AQUIND INTERCONNECTOR

Consultation Report – Appendix 1.7E Marine
Specific – Briefing Note of Ongoing
Consultation with Environment Agency

Natural Power Memorandum			
To	Environment Agency	Date	July 2019
From	Natural Power	Ref.	1199526

Briefing Note to inform Ongoing Consultation: Responses to PEIR feedback

TITLE: **Figure 3.12  
Construction Corridor Assumptions  
HVDC Cables - Highway  
Sheet 1 of 2**

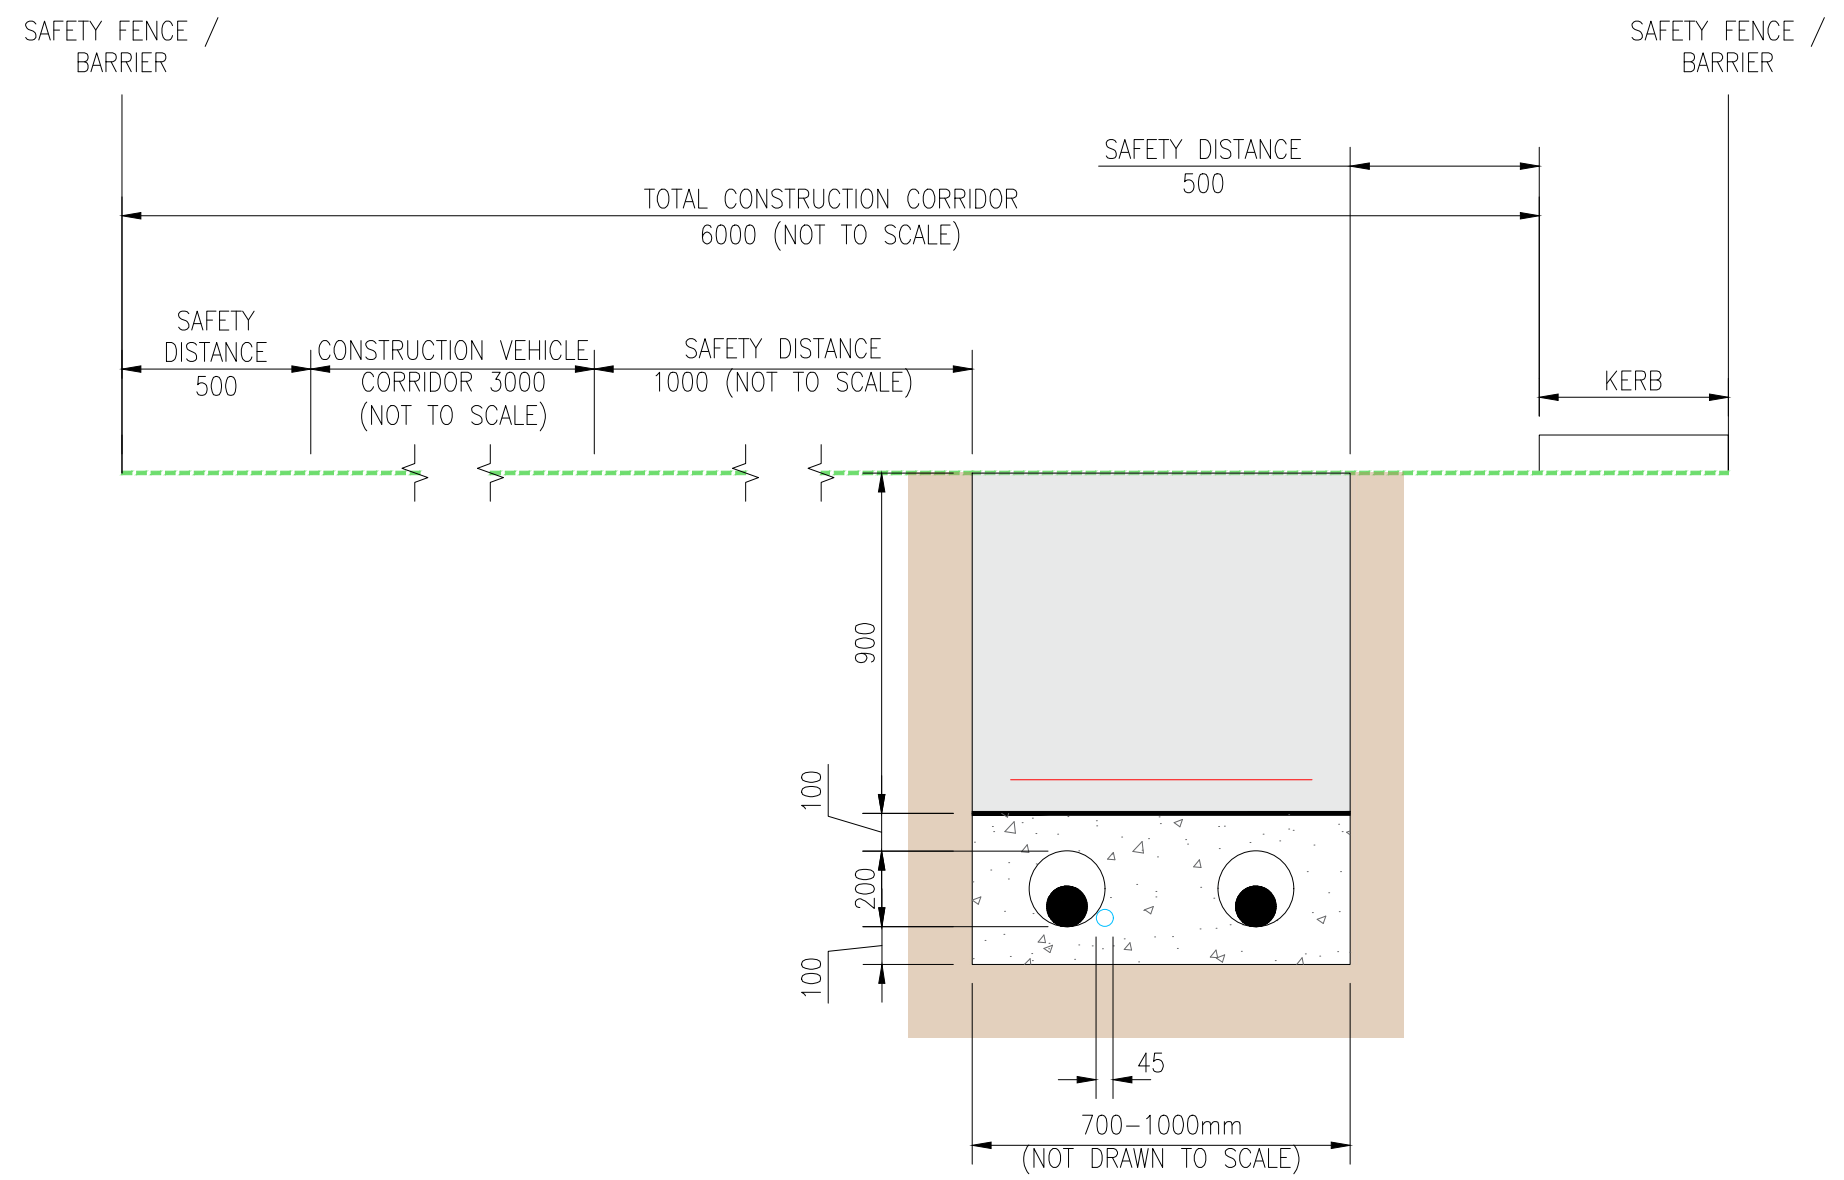
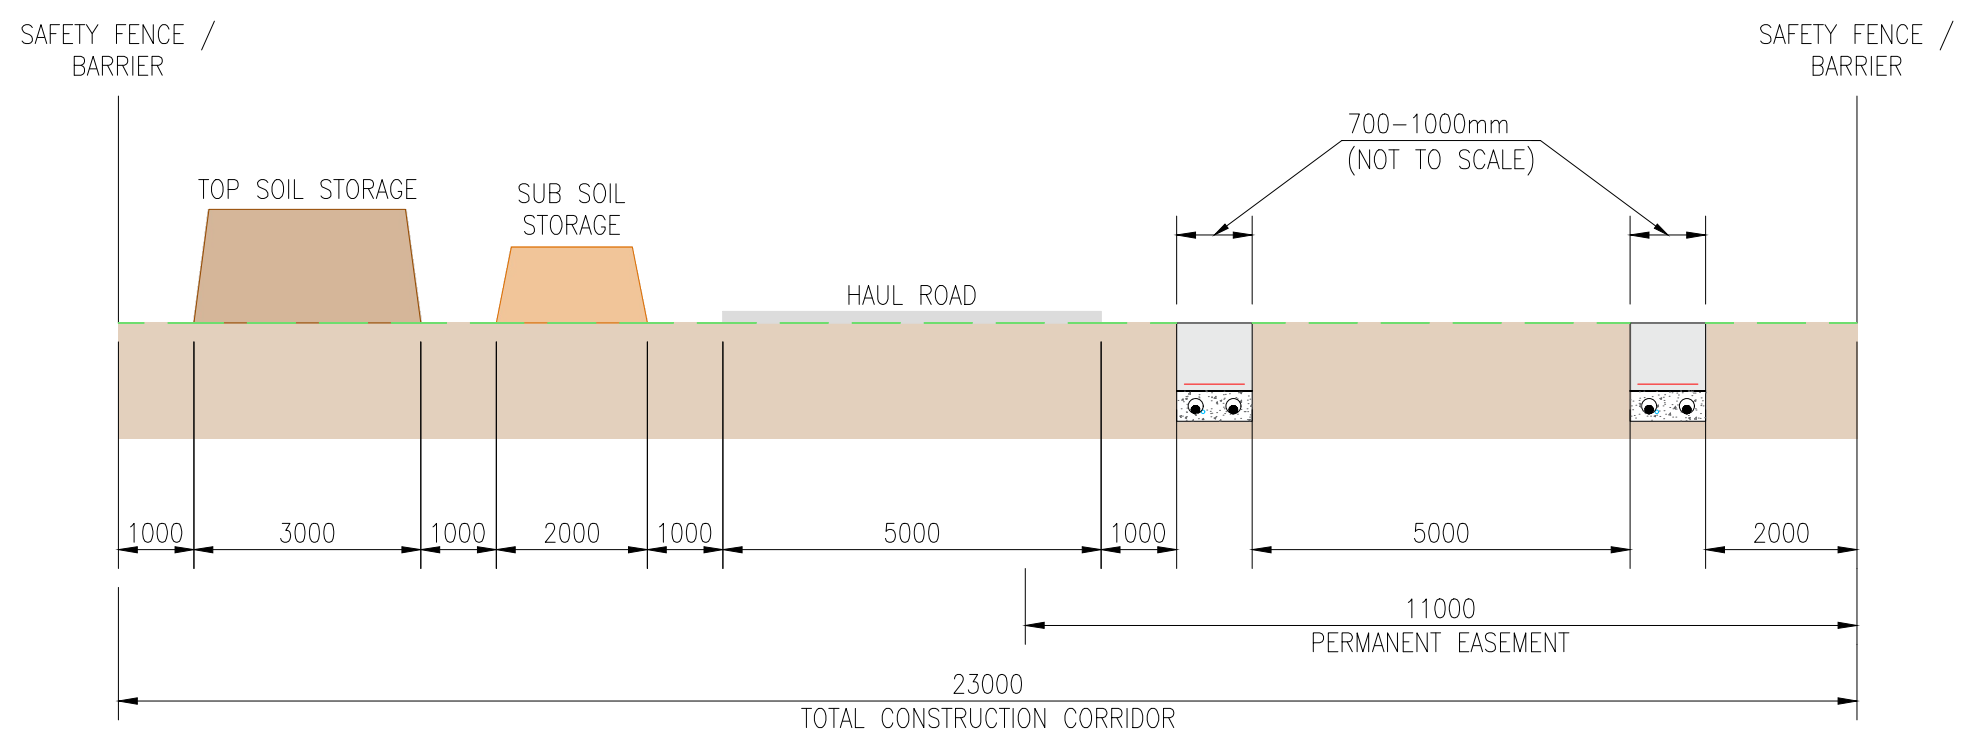
18	Fish and Shellfish	Table 9.8. Cable depth is cited as being between 0.6 and 5.1 metres. It is unclear how the depth of cable will be determined at any given location. This should be specified within the ES. The likelihood of impact, on migratory fish, from suspended solids and/or others, is increased the deeper the depth of the trench.	<p>Cable depth is dependent on seabed conditions, and the likely burial depths will be informed by a Cable Burial Risk Assessment (CBRA). Further detail will be covered within the description of the Proposed Development once it has been refined.</p> <p>The effect of suspended sediment concentration (SSC) on migratory fish will be assessed in the final ES chapter.</p>
